CITY OF ALBUQUERQUE

January 8, 2015

**Re: Drainage Report Addendum for La Cuentista II
Engineer's Stamp Date 12-30-14 (D10D002B)**

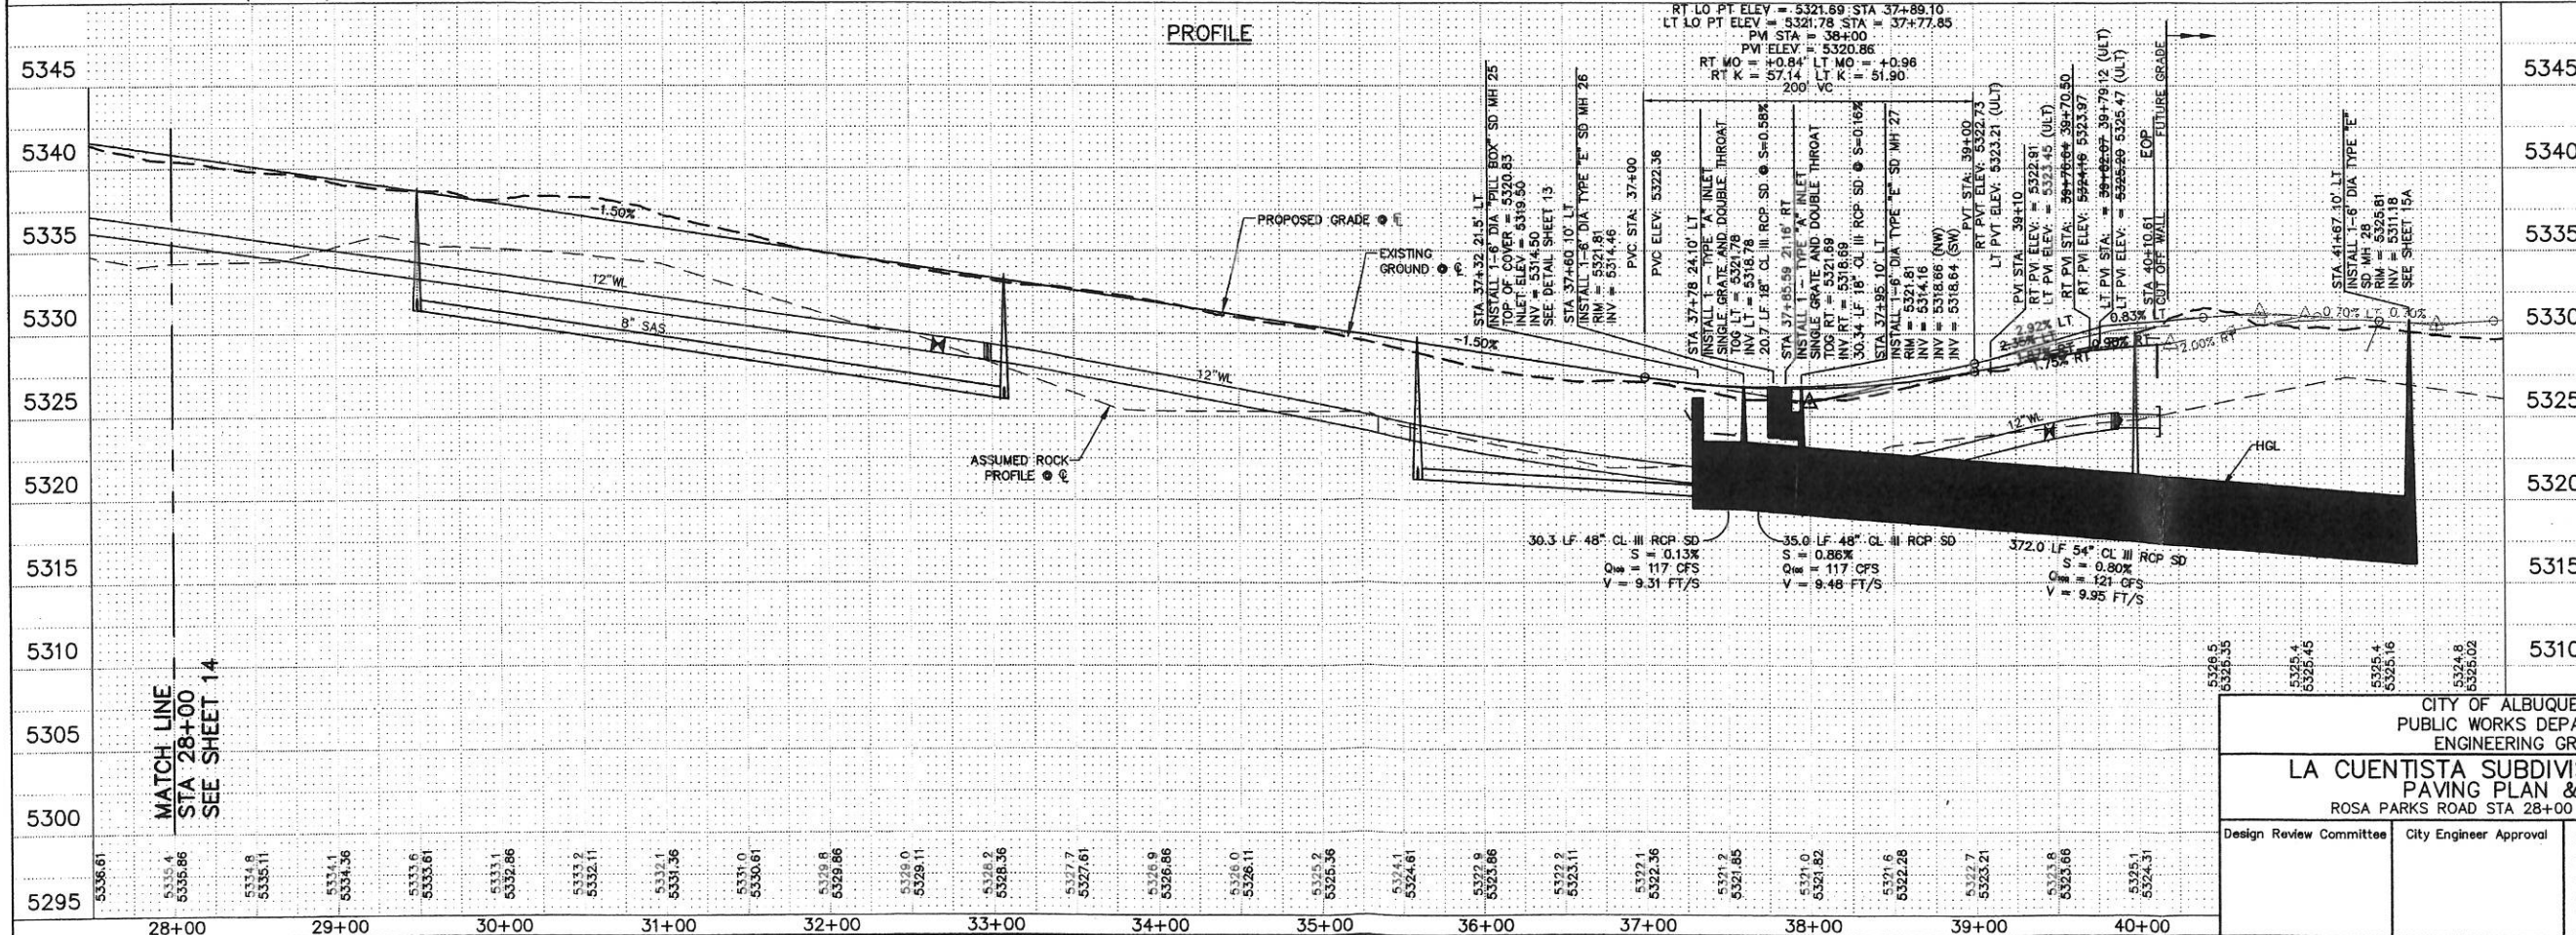
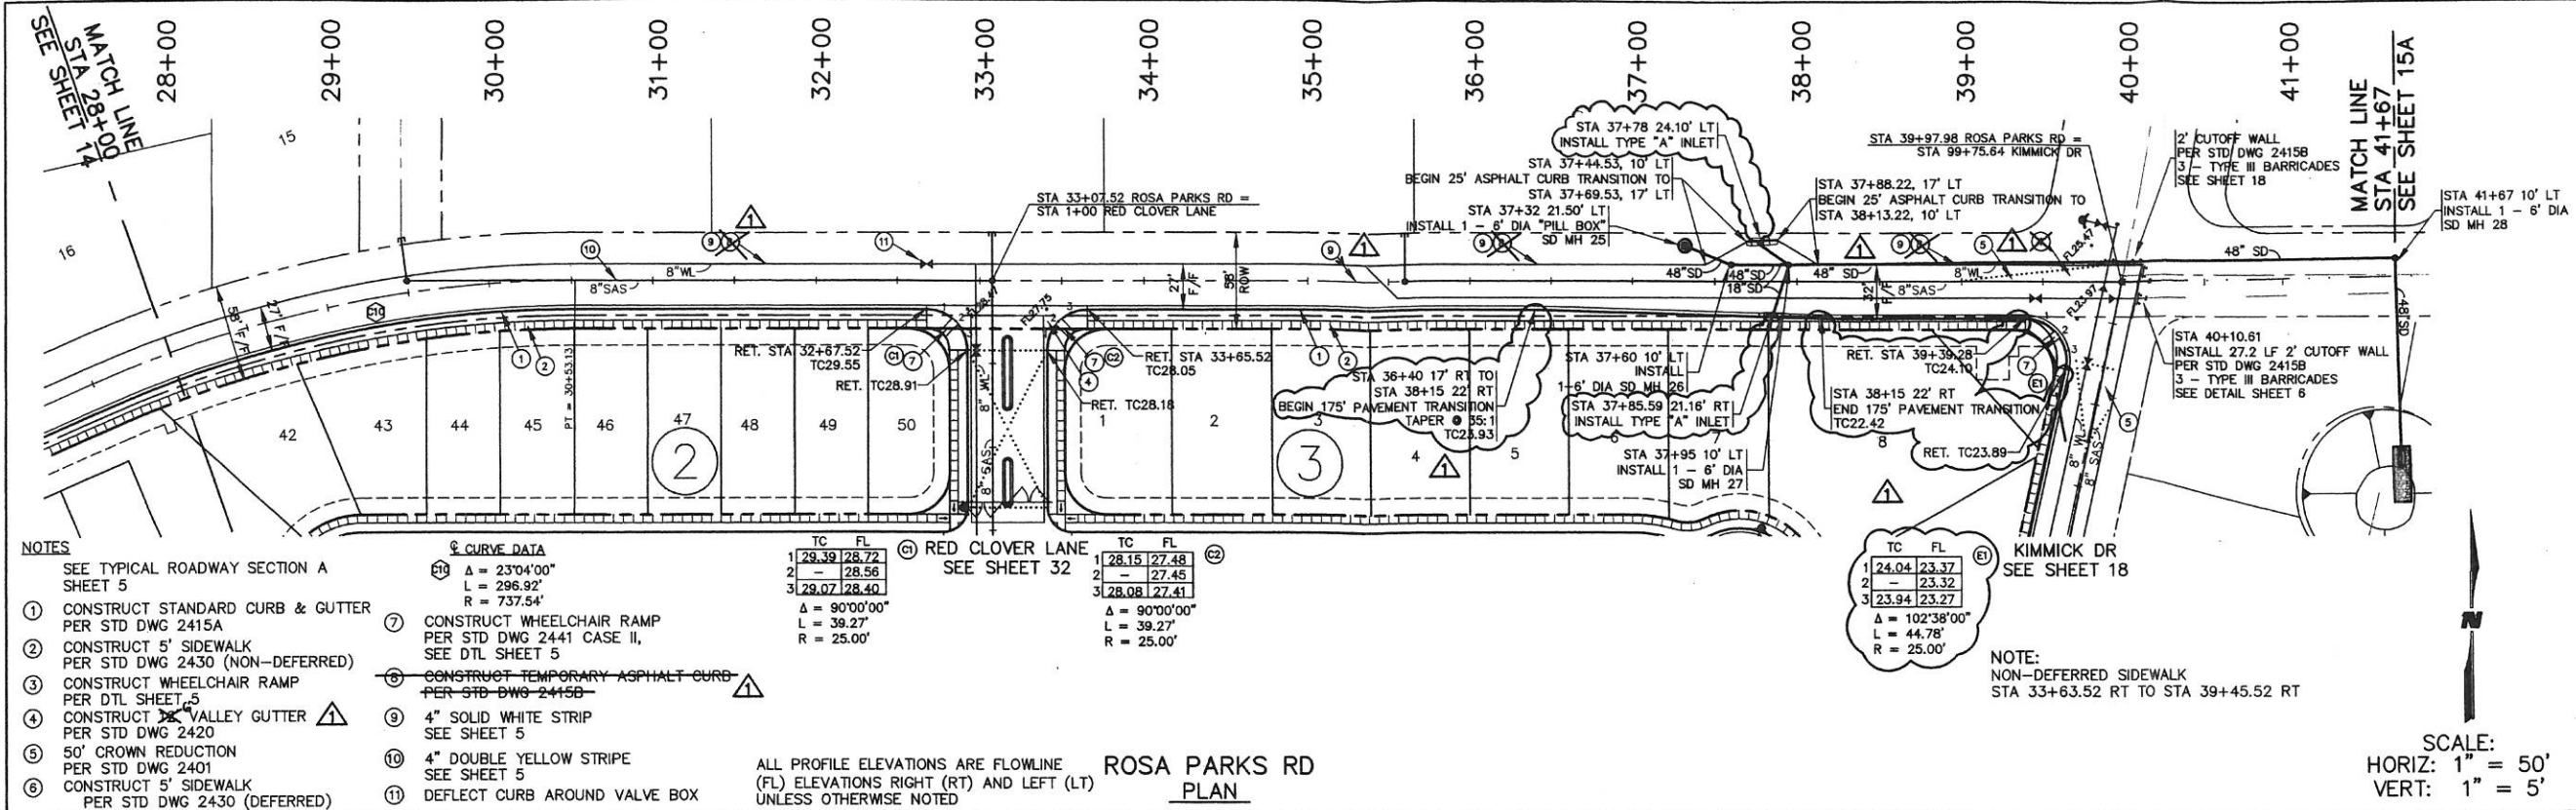
5. It appears the last sheet in the report (sheet 15 of 37) may have been mislabeled as with AP-3. Isn't this sheet applicable to AP-4?

TC FL (A3)

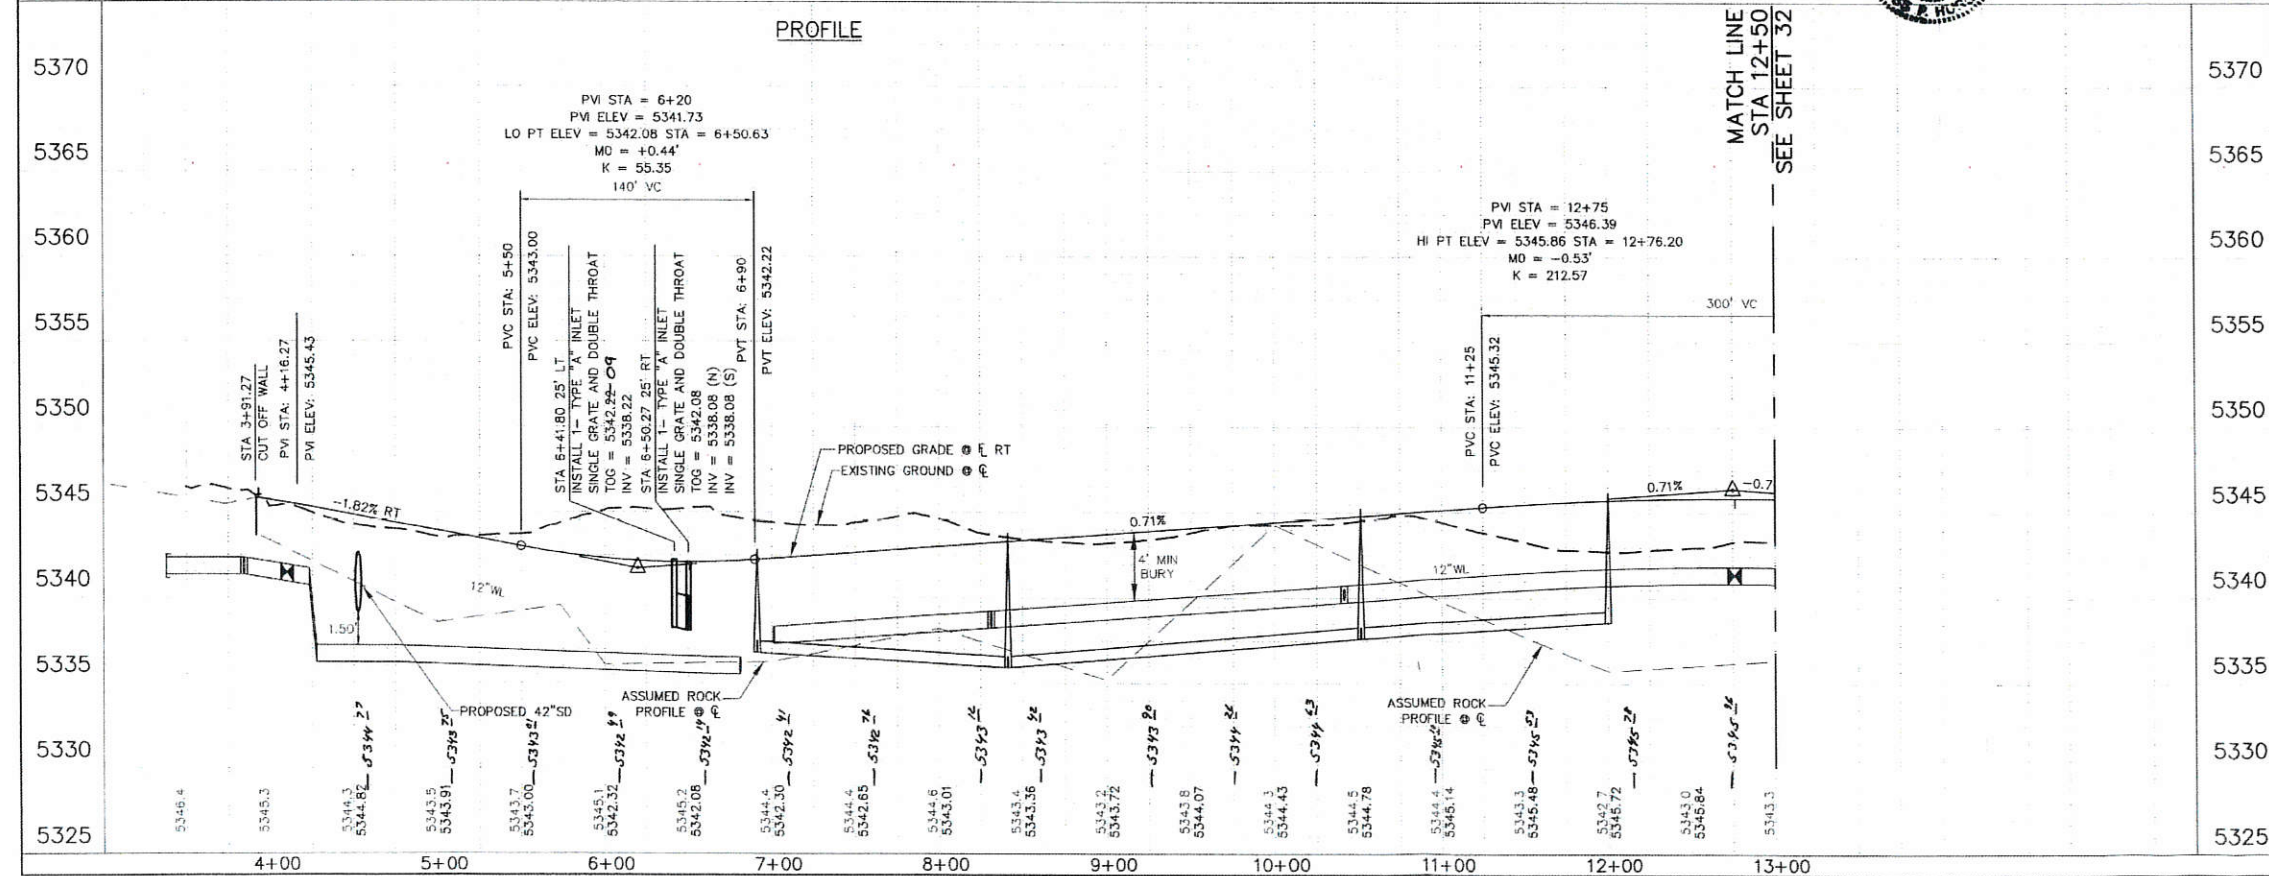
4. On the "Combination Inlet in Sag" calculation sheet; why was 21.35 cfs used when it appears the flow reaching these inlet is 32 cfs? Why is it labeled AP2 and AP3 when it receives stormwater from basin OS-7 (AP-3)?
